Planning & Urban Development Department

April 11, 2014

RE: 478 Island Ave - 90-J-001 and 60 Oaklawn Ave – 90-J-002 & 90-J-009, Peaks Island

SP.1

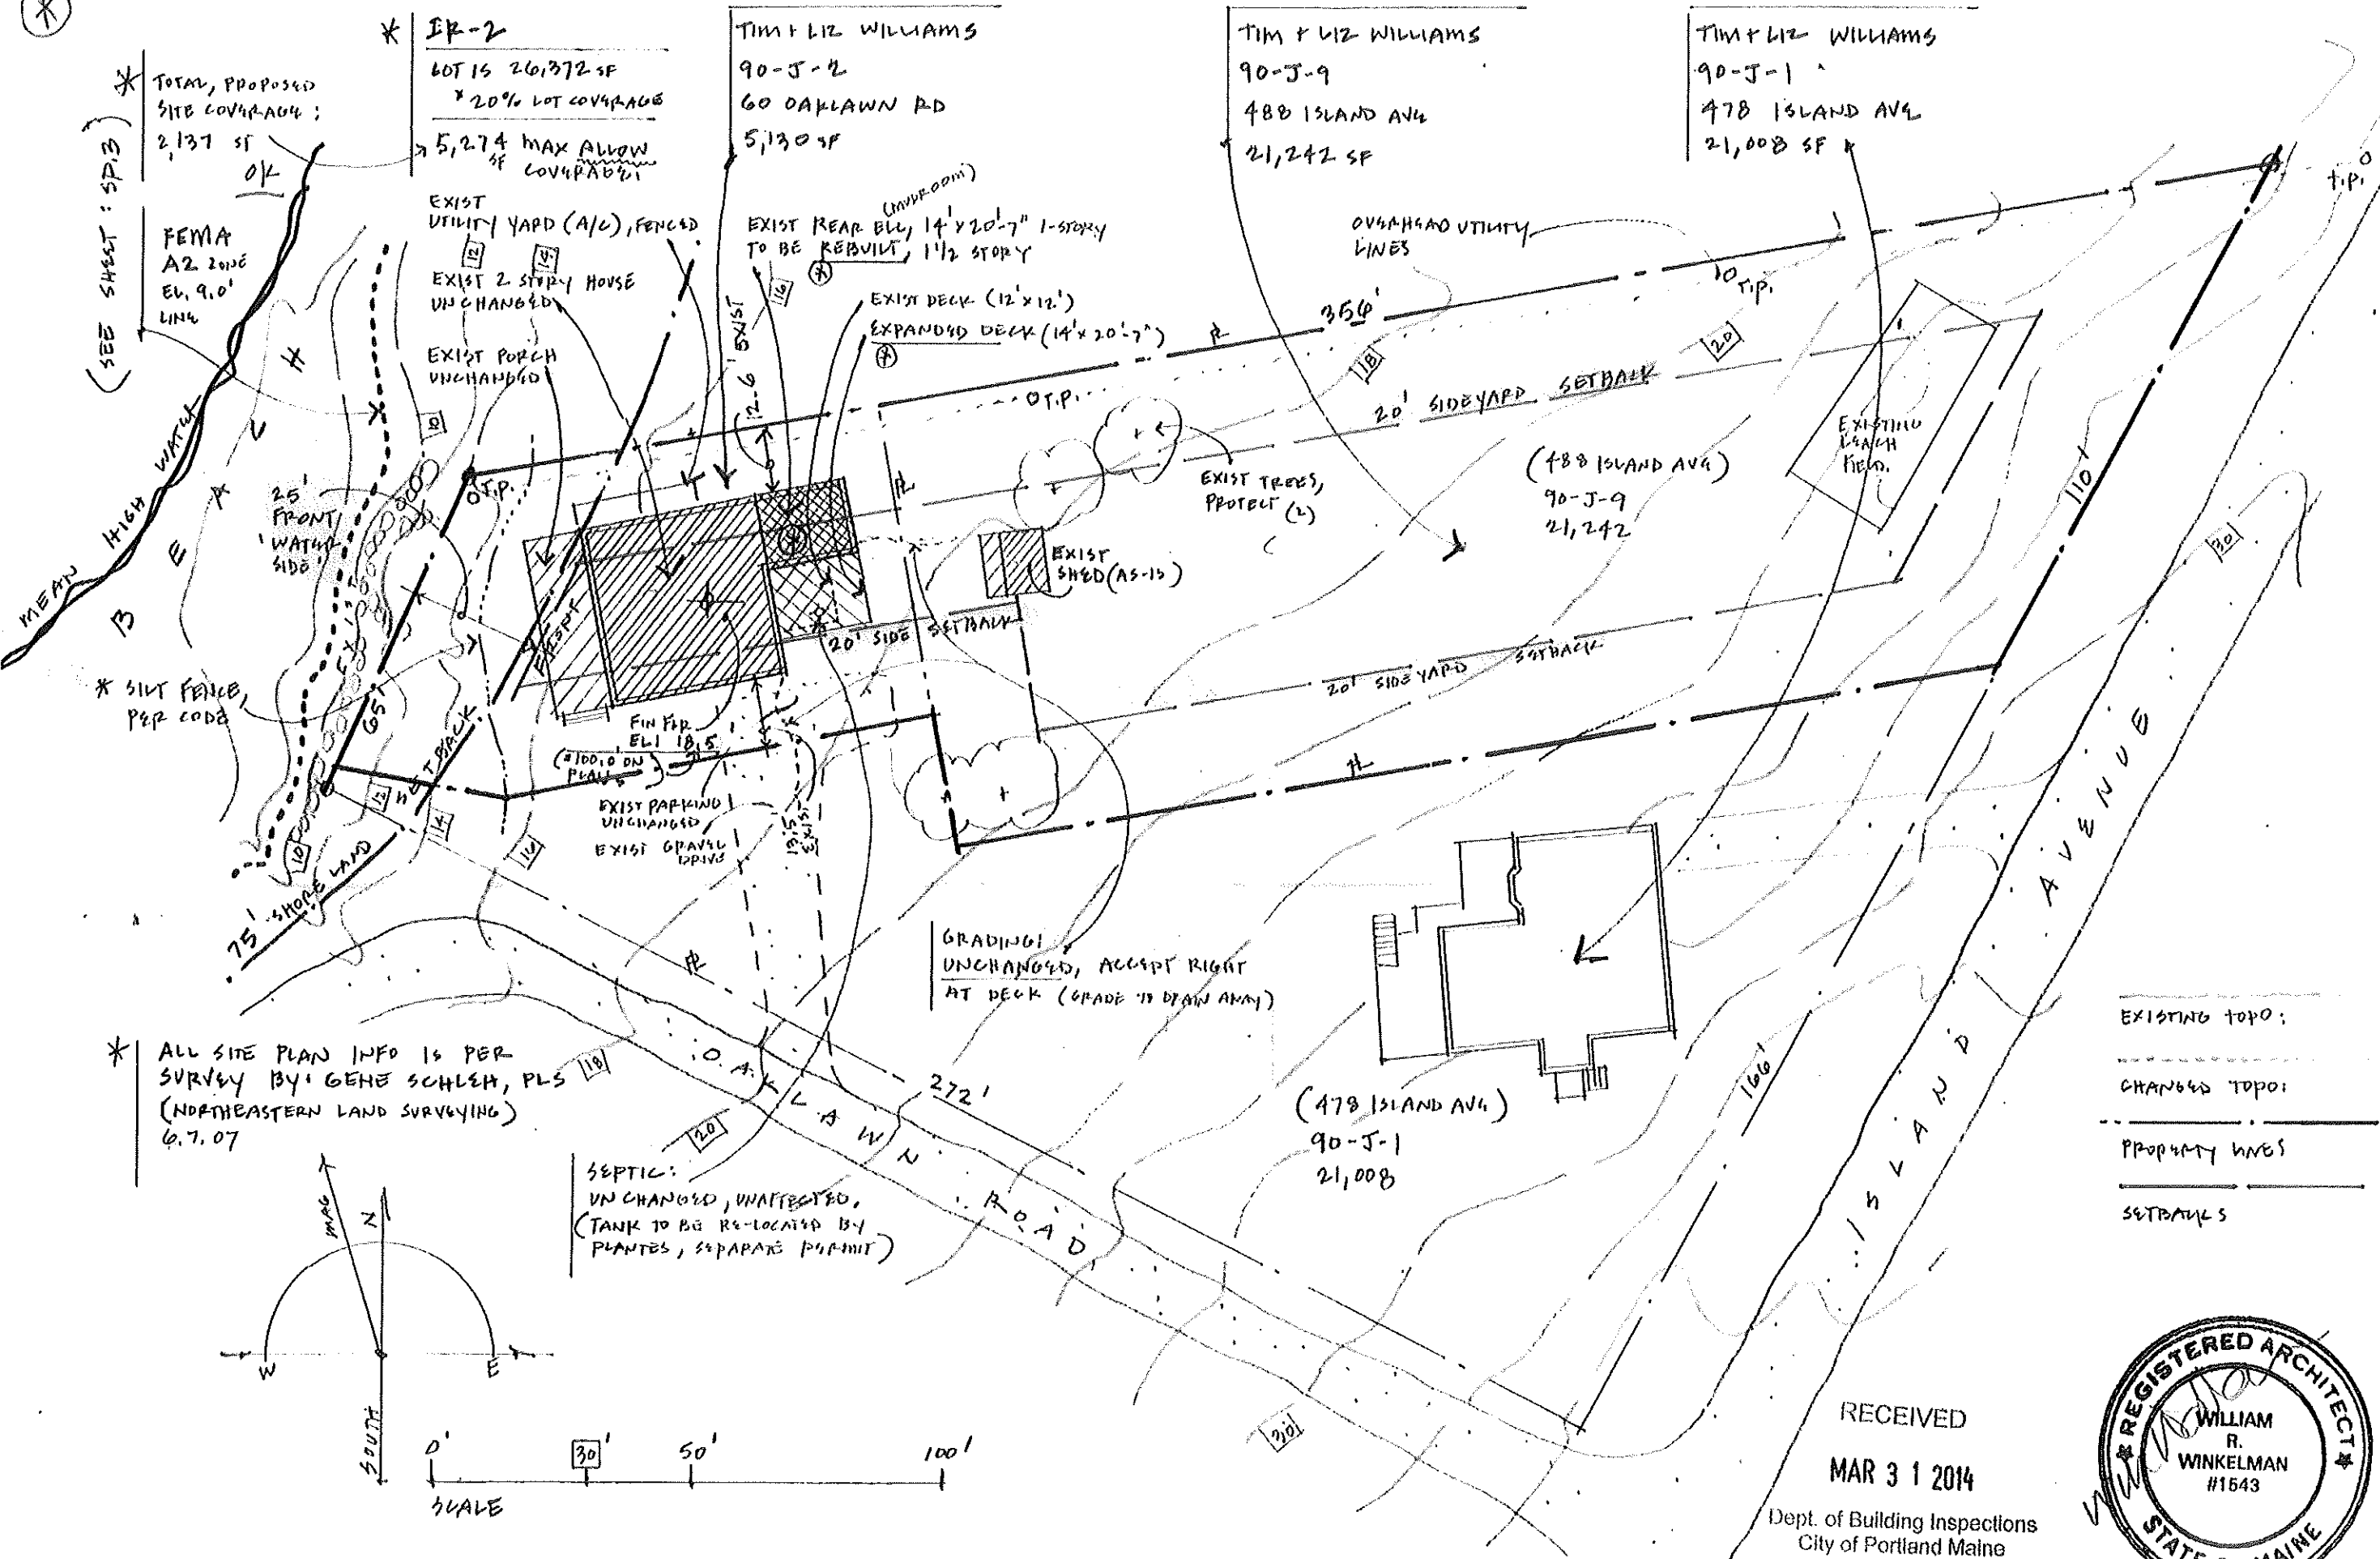
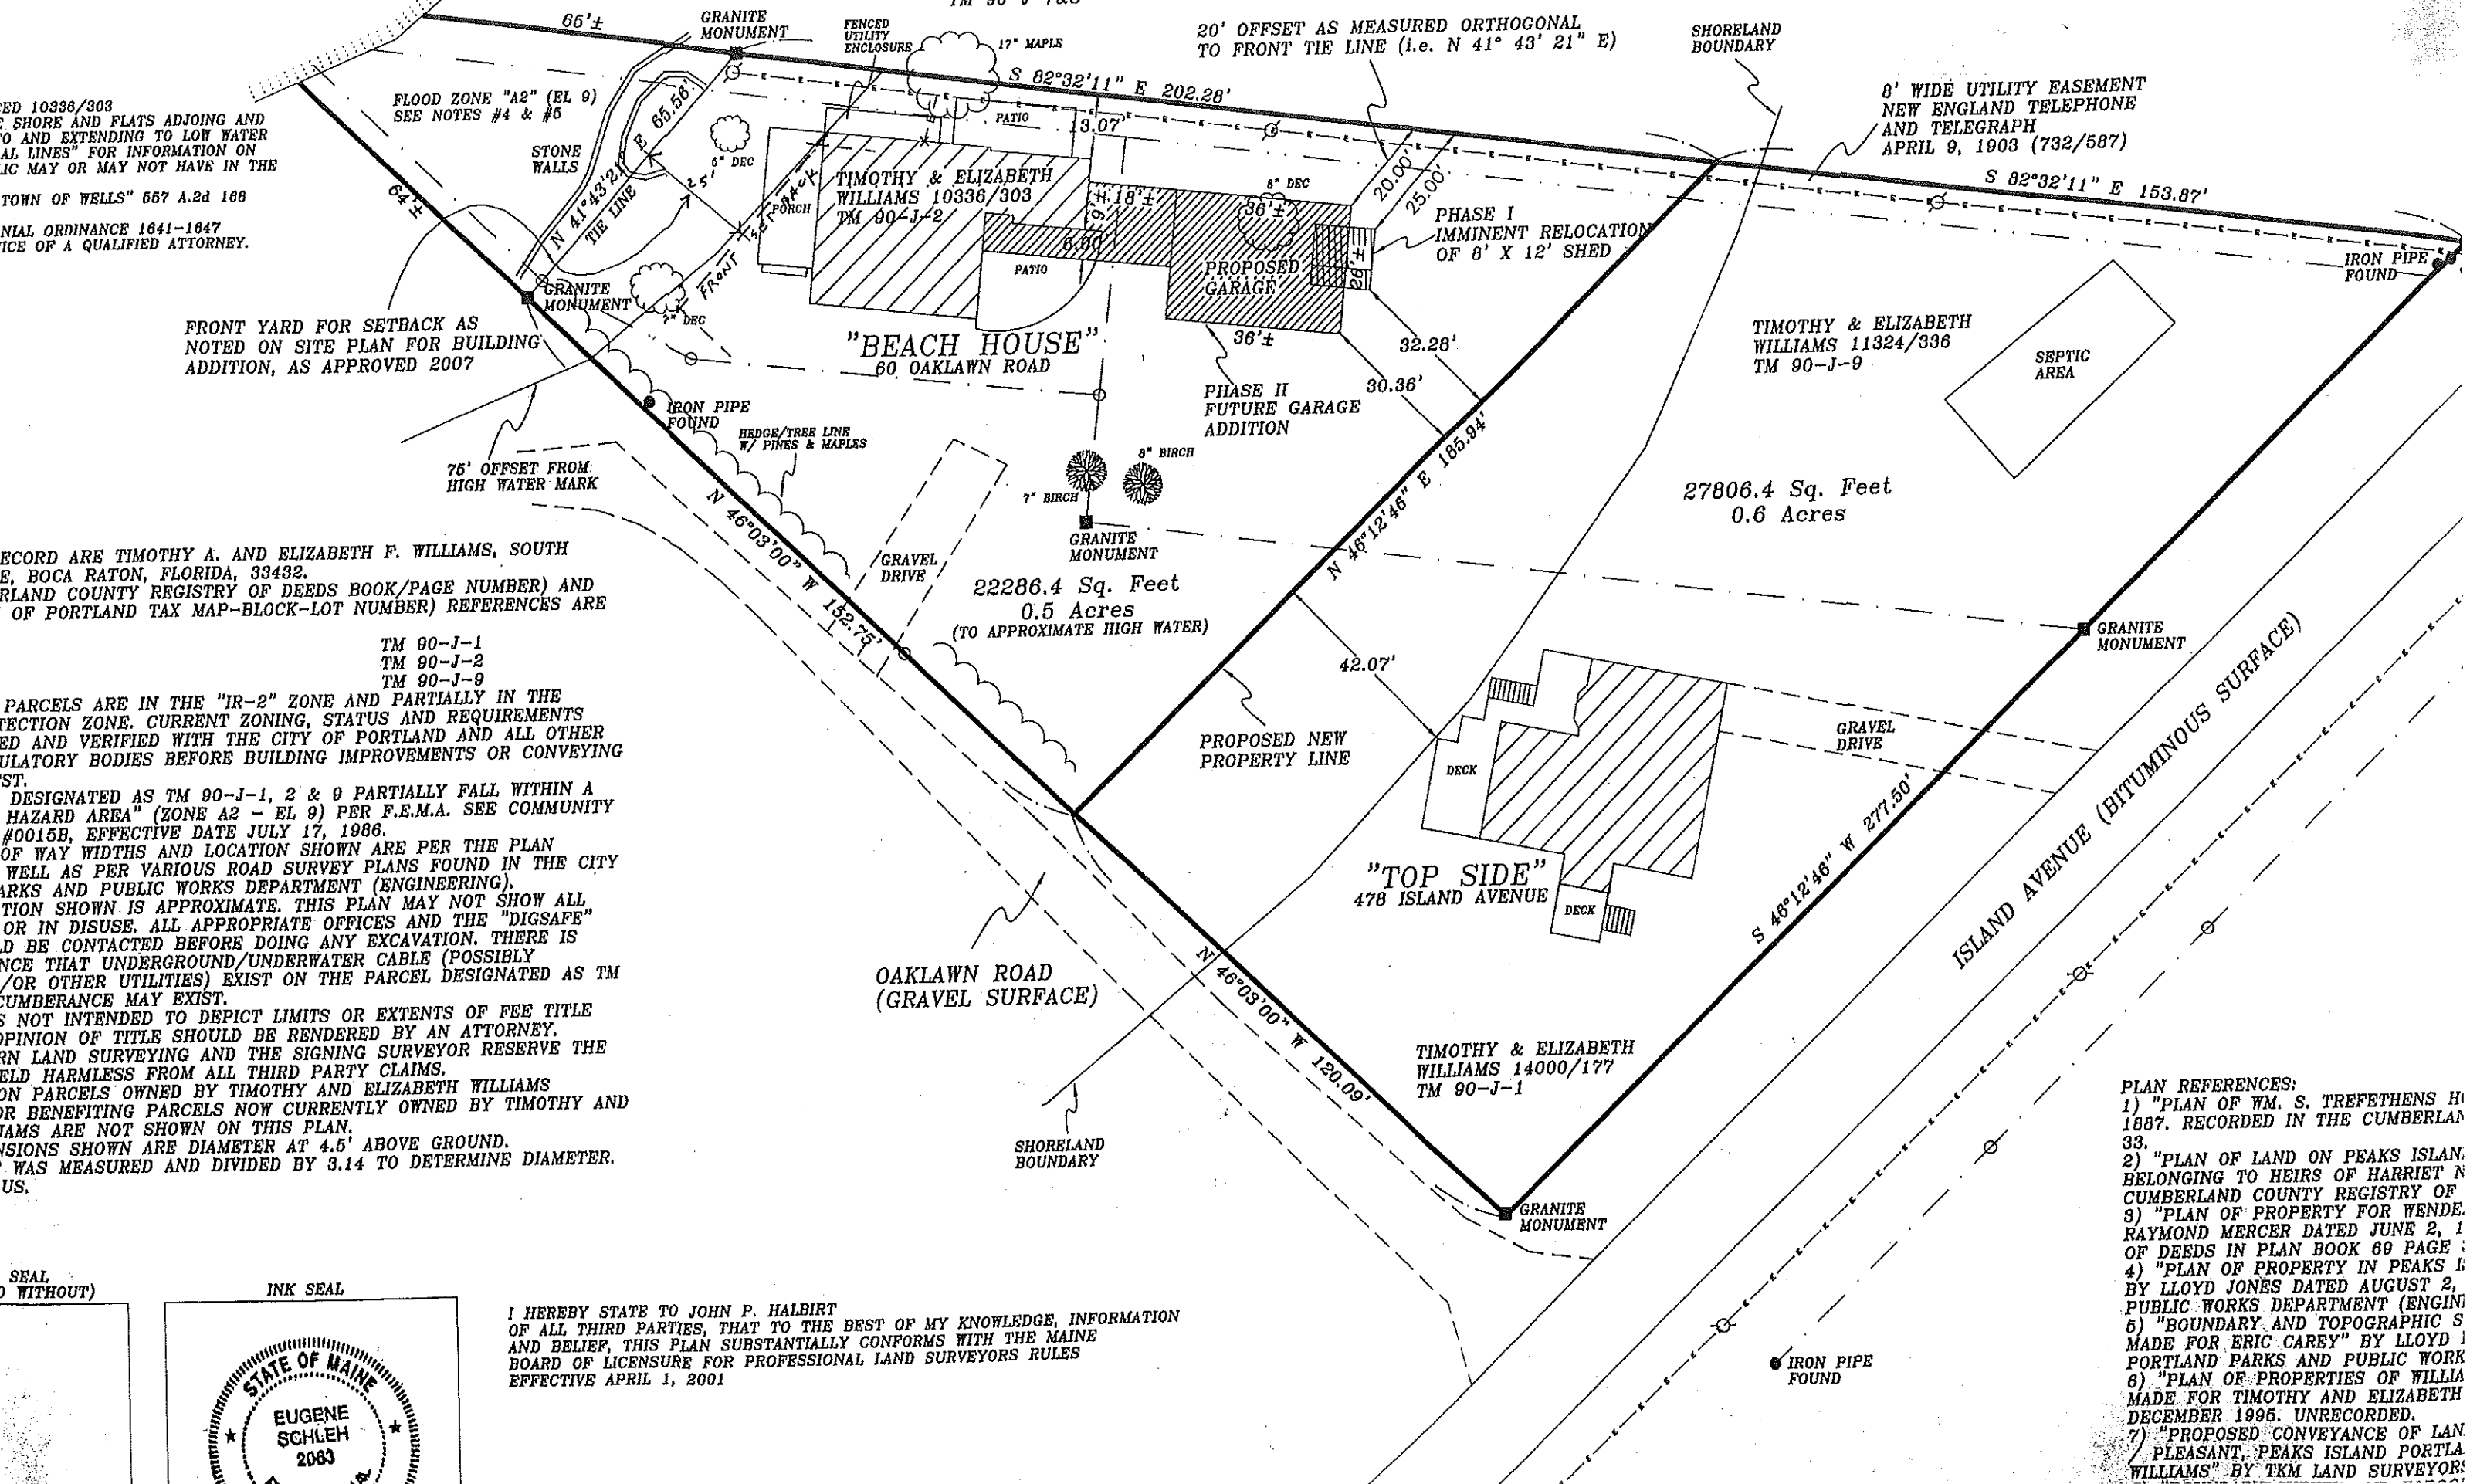
The redefined property lines result in two lots, Beach House at 60 Oaklawn Road, and Top Side at 478 Island Avenue. Both of the new lots are meeting the minimum land area requirements of 20,000 square feet. The proposed division line results in both lots meeting the minimum setback requirements as affected by the new division line. I have determined that the new division line does not create any non-conformity under the Land Use Zoning Ordinance. It is further understood that the 8'x12' shed will be relocated as shown on the Beach House property and meets the dimensional requirements of the IR-2 Zone.

The survey also shows a phase II proposed future garage addition on the Beach House property. I have determined that what is depicted will not violate the IR-2 Land Use Zoning Ordinance. However, this determination is not a final approval to begin construction on this proposed garage. Separate application(s), review(s) and approval(s) will be required prior to any work commenced.
